Single storey front extension  
8 Osborne Way Bognor Regis West Sussex

Thank you for your internet comments made on 28th November 2018 which has been recorded as **'an objection'** with the comments as follows:

PROPOSED GROUND FLOOR PLAN

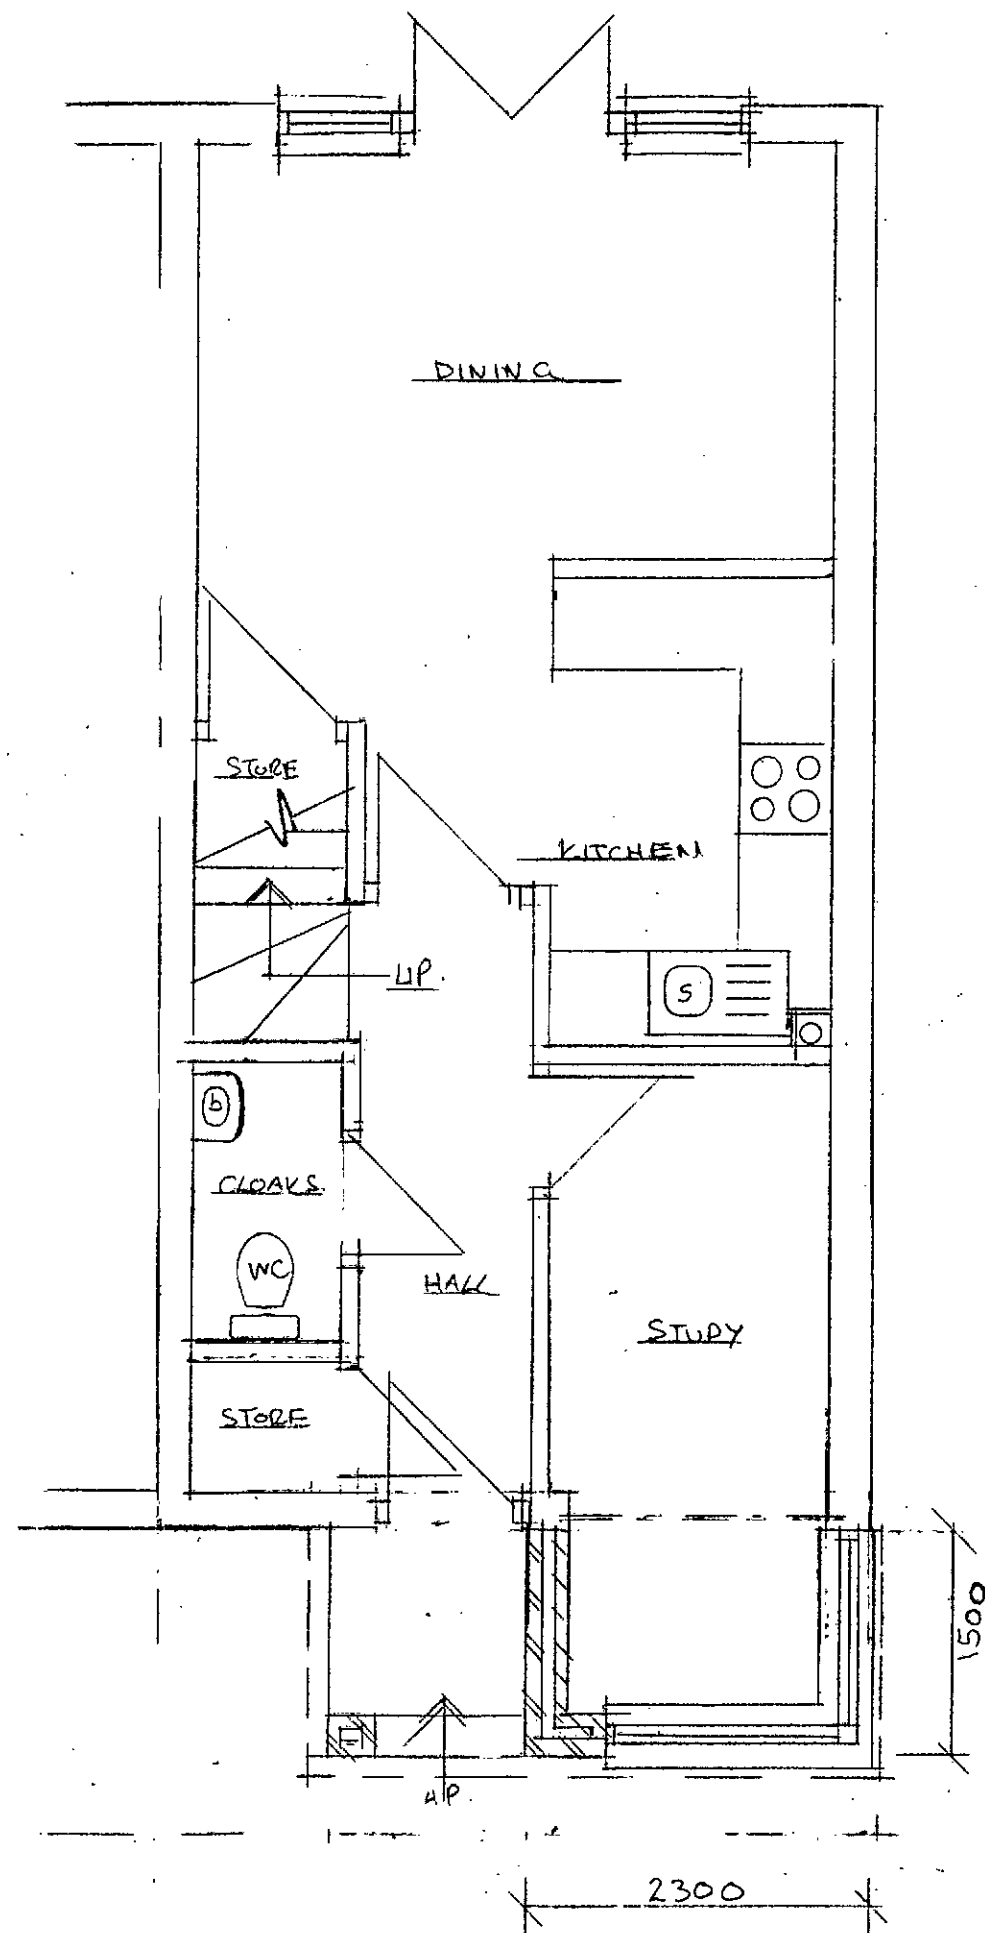
*Members strongly opposed the application on the grounds that the proposed extension does not sympathetically relate to and is not visually integrated with the existing building in in siting massing design form scale and materials; because it has an adverse overshadowing overlooking or overbearing effect on neighbouring properties; and because it compromises the established spatial character and pattern of the place. Therefore Members agreed that the application is in direct conflict with Policy D DM4 of the Arun District Council Local Plan 2011 to 2031 and with the Parish Design Statement Page 7.*
